From: Kim Morris 
Sent: 08 May 2019 13:07
To: Anita Gardner
Subject: Application_Ref_No=R/72/19/PL

We live at number 1 Grafton Close and will be affected by any proposed development at 6 Manor Road

DRAWING: PROPOSED NEW DWELLINGS - PLANS **SCALE:** 1:50 @ A2 **DATE:** 24/04/2019 **DRAWING No:** DS/6MANOR/04 rev 1

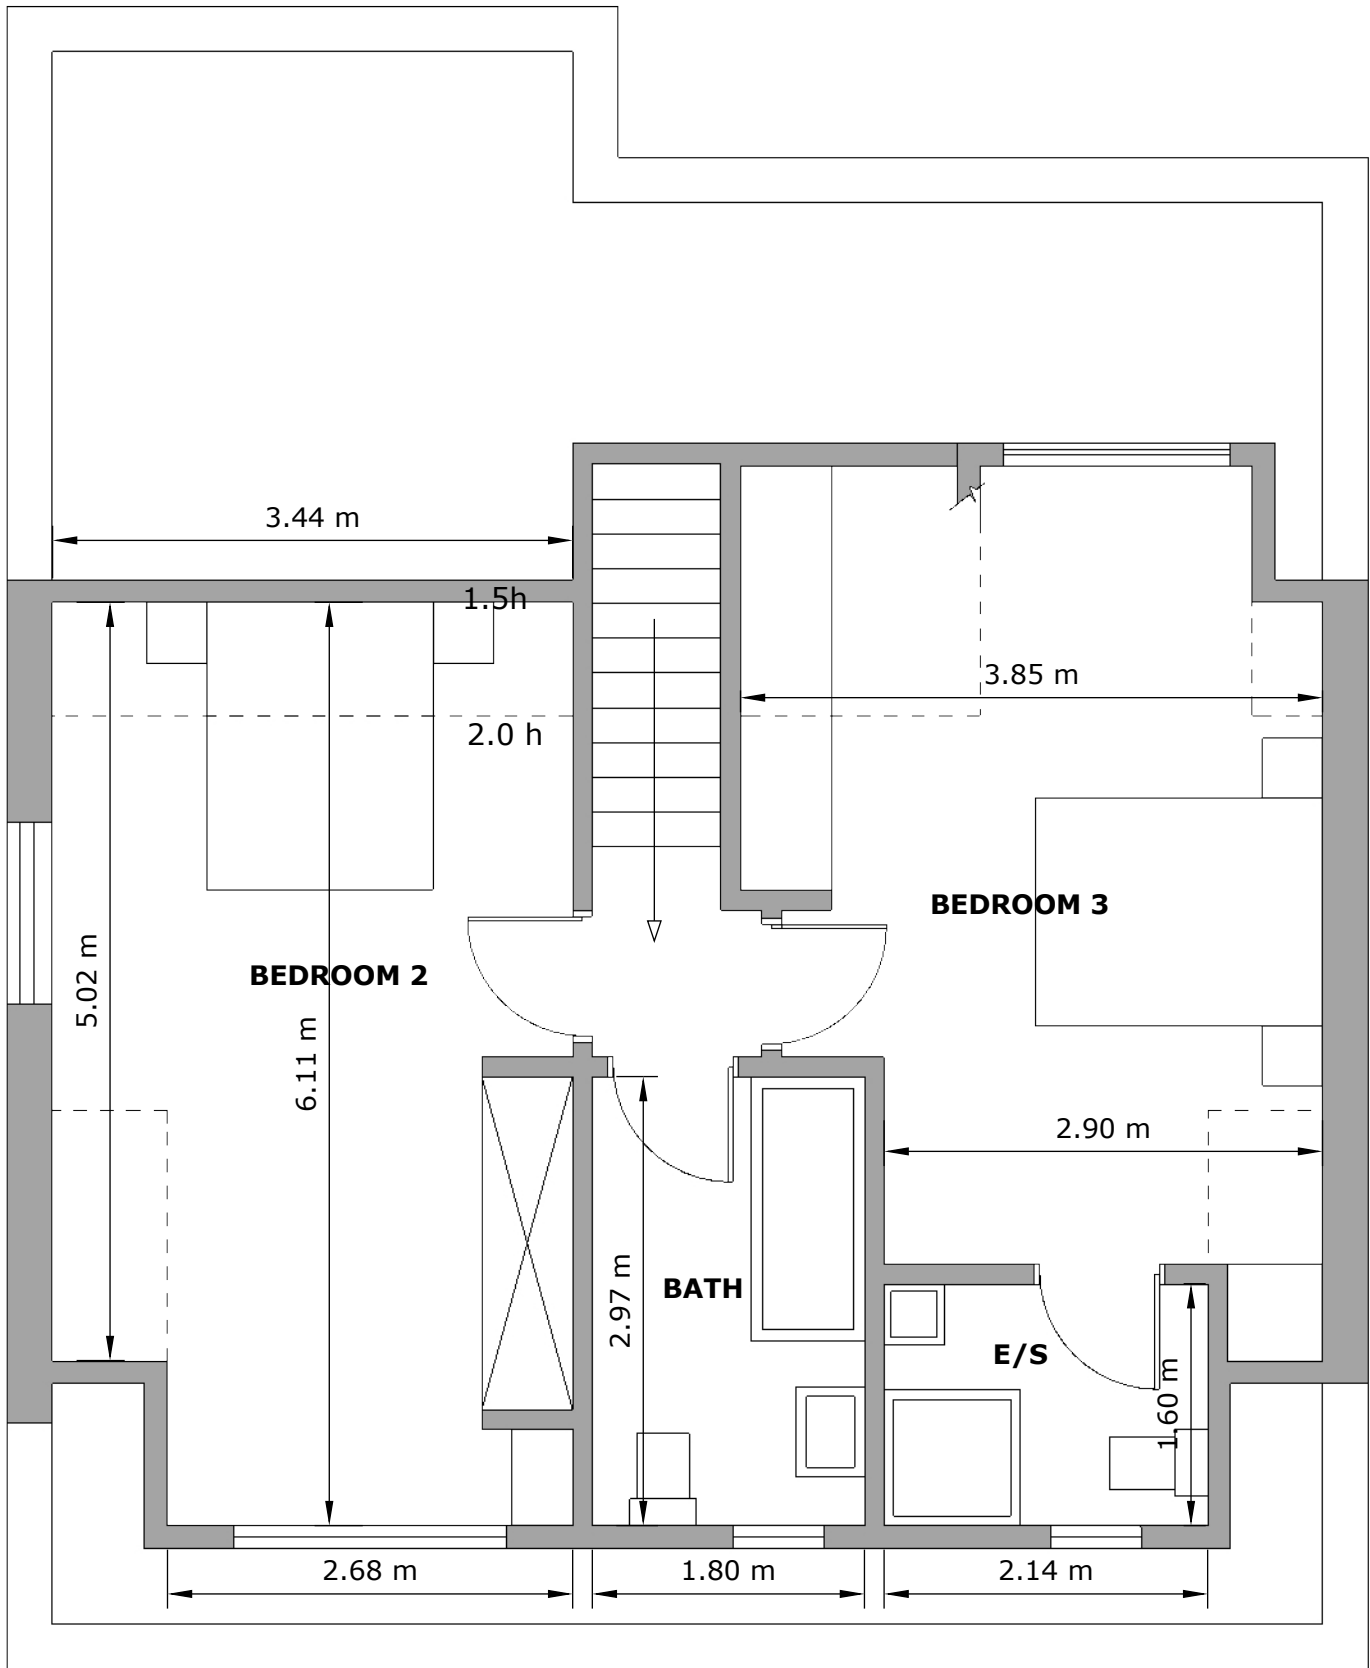
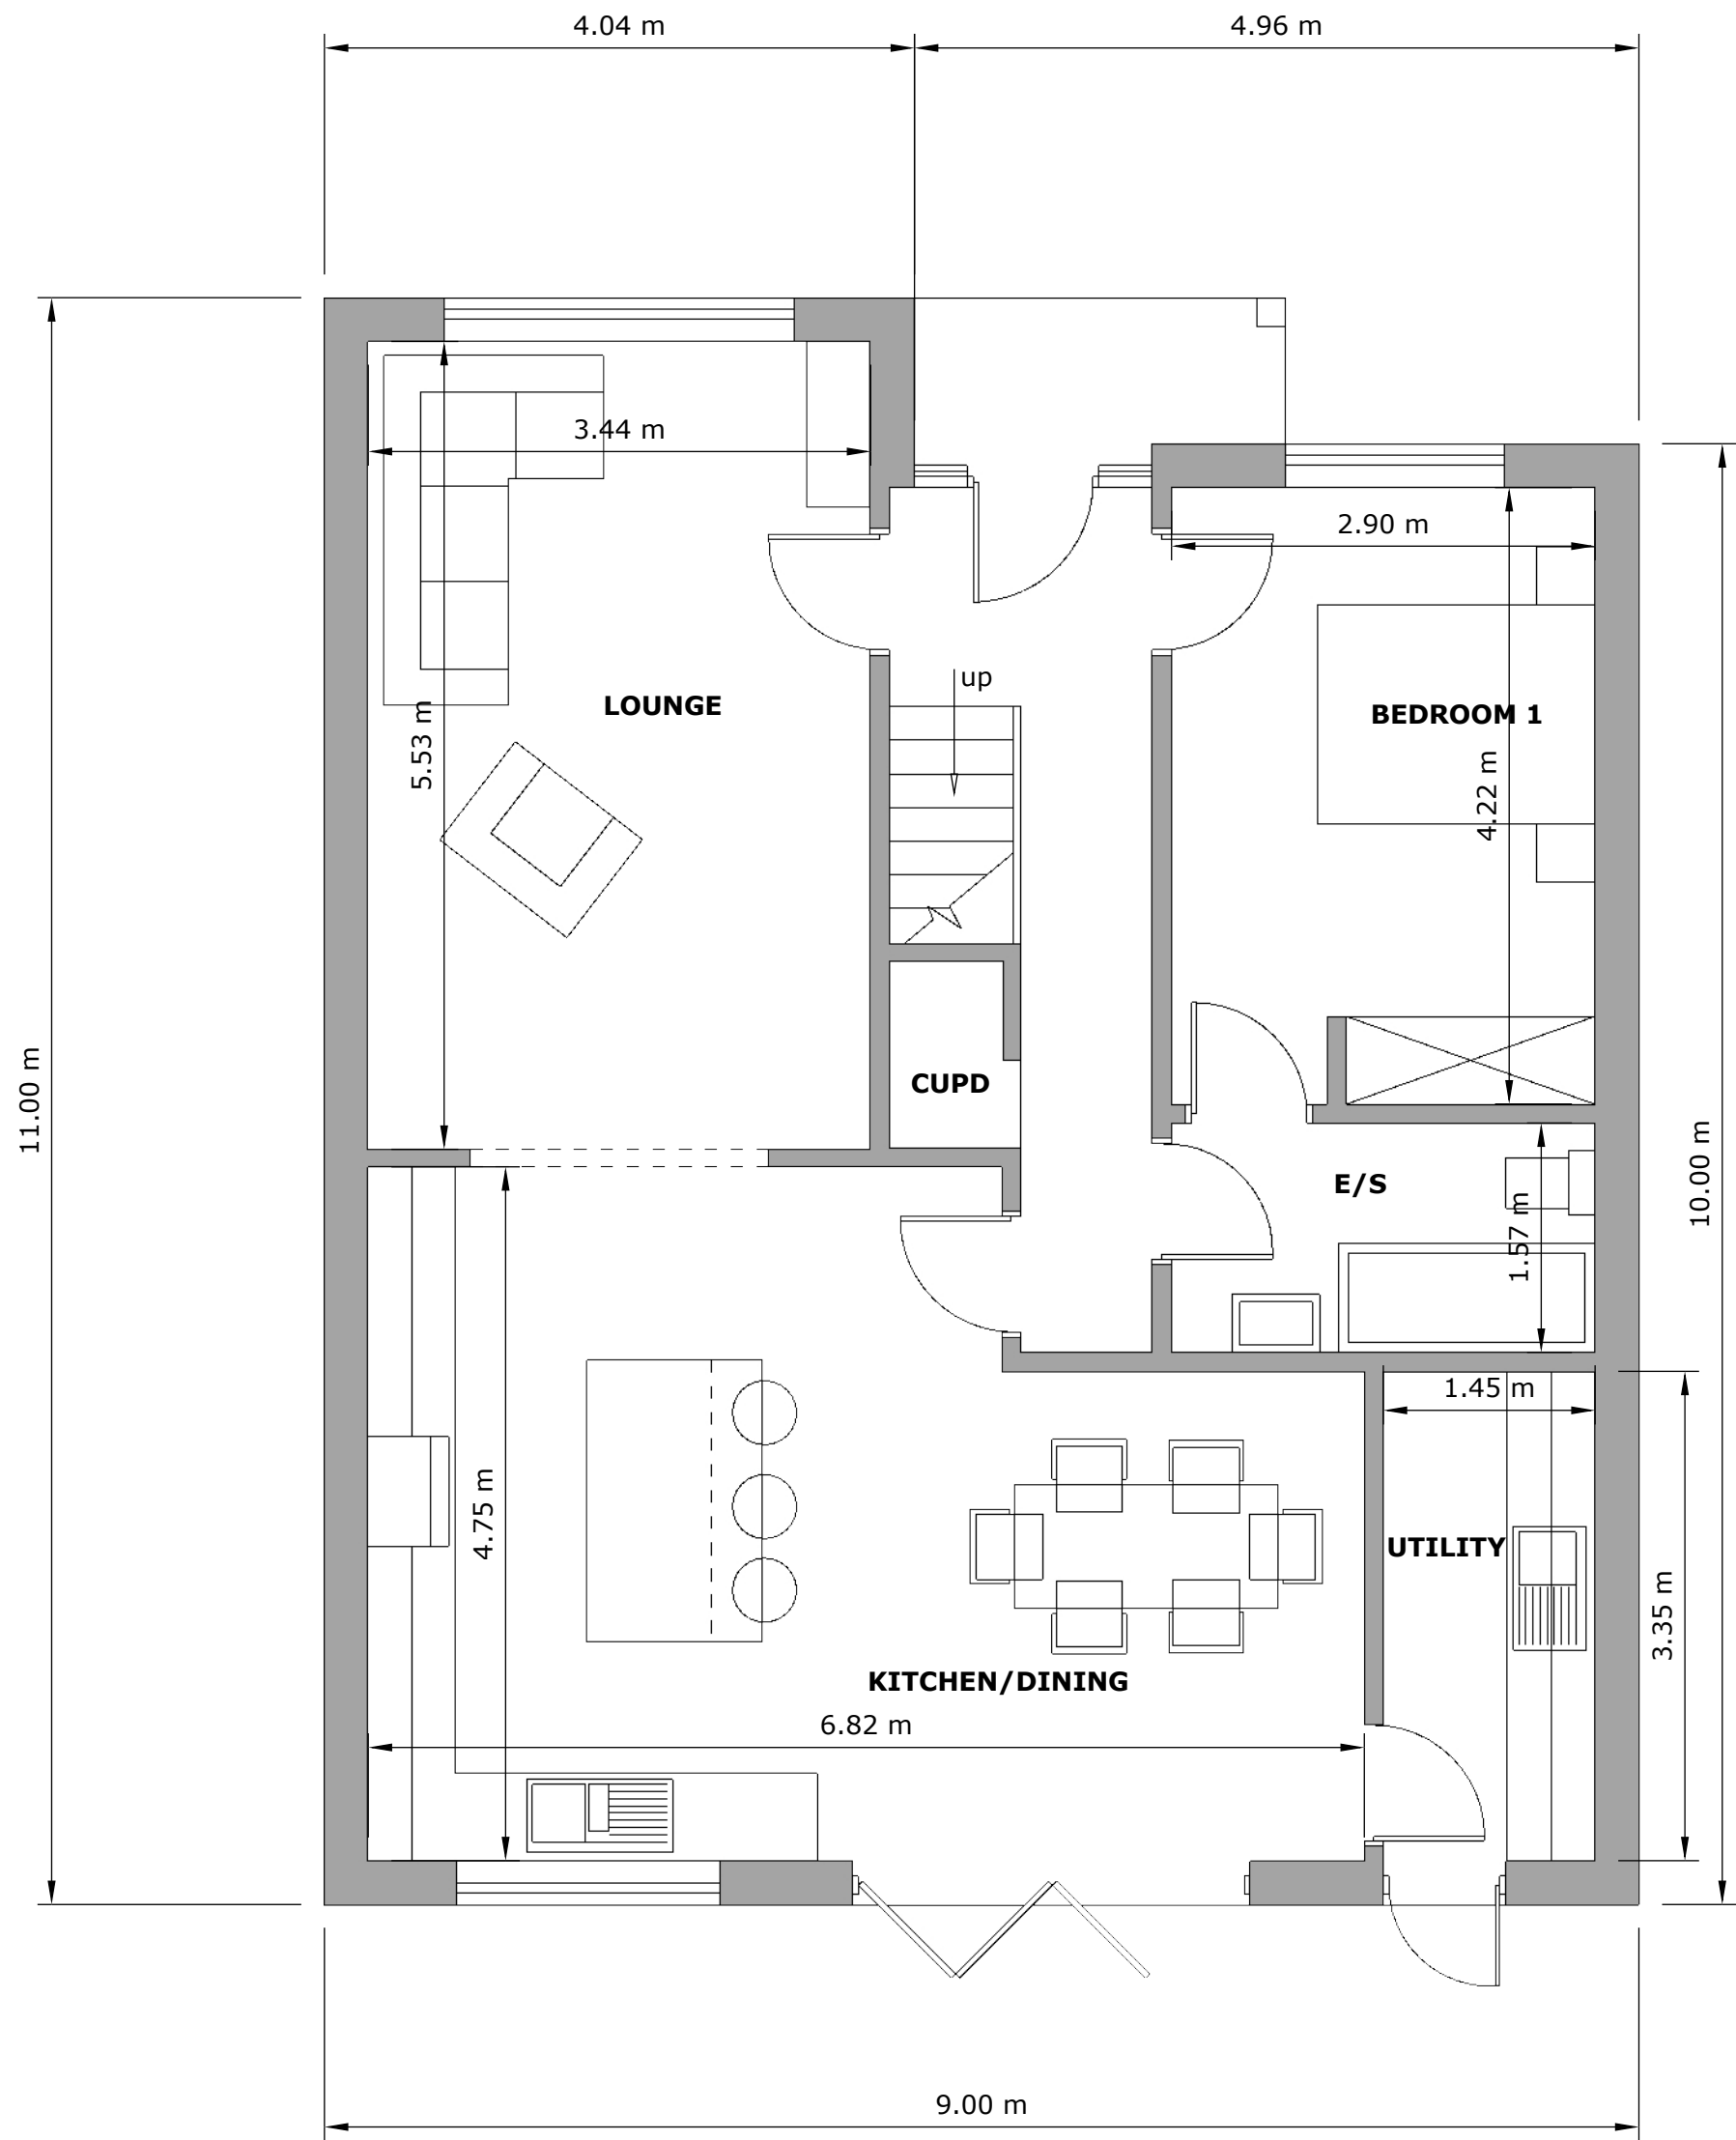
- The Design and Access Statement, first paragraph (introduction) is referring to a "Generous 4-bedroom detached bungalow with garage to each side", I see neither 4 bedrooms on the plan view or facility for a garage or reference to a bungalow

DRAWING No: DS/6MANOR/03 rev 1

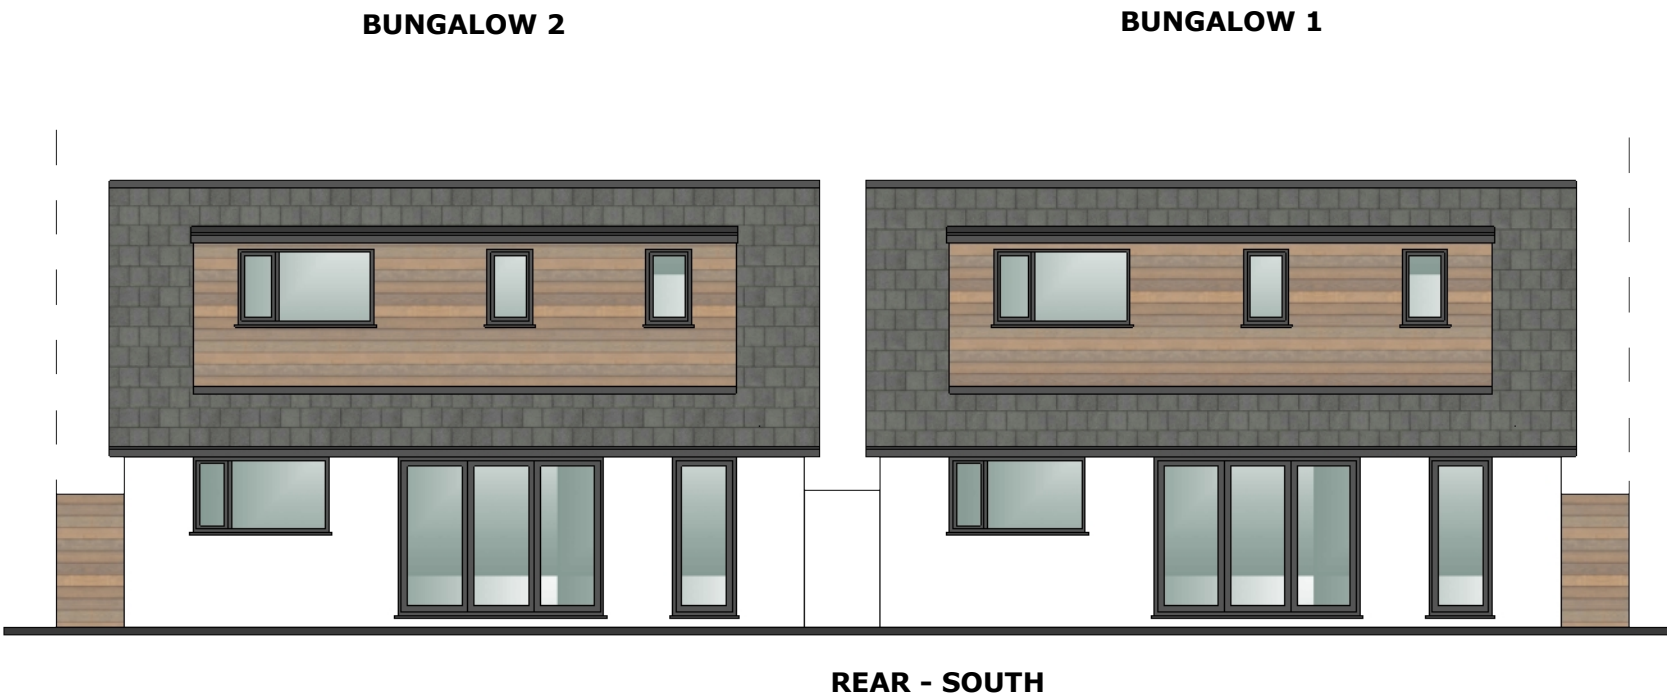
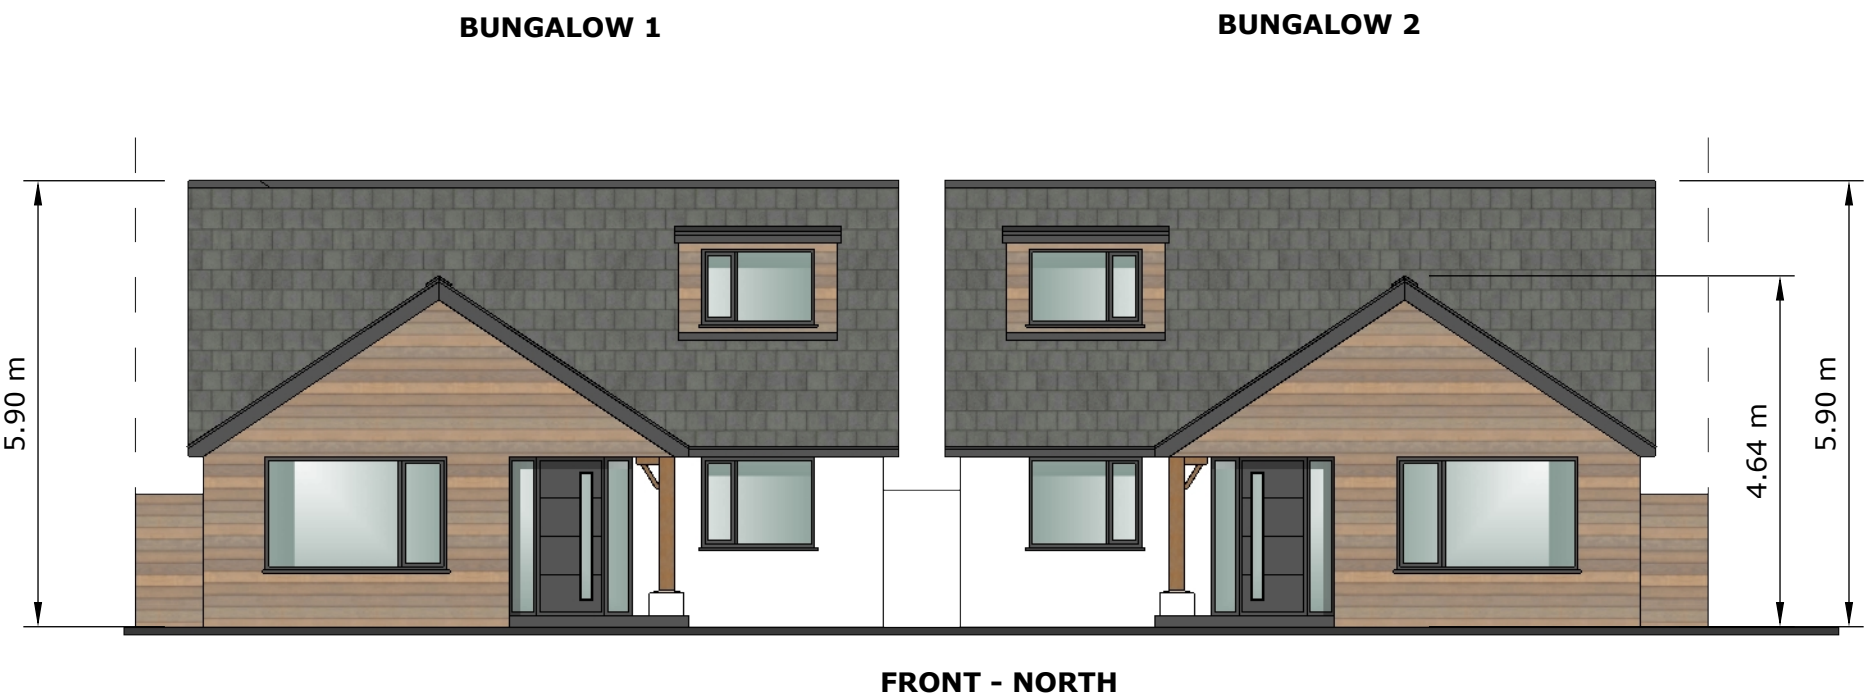
- The Elevation Street Scene does not accurately reflect the true ridge height of the proposed dwellings, even though the new ridge height is 5.9m that is still a differential of 0.95m higher than the existing building line of numbers 2,3 and 4 Grafton Close, still not sympathetically keeping in context with the surrounding existing dwellings and environment
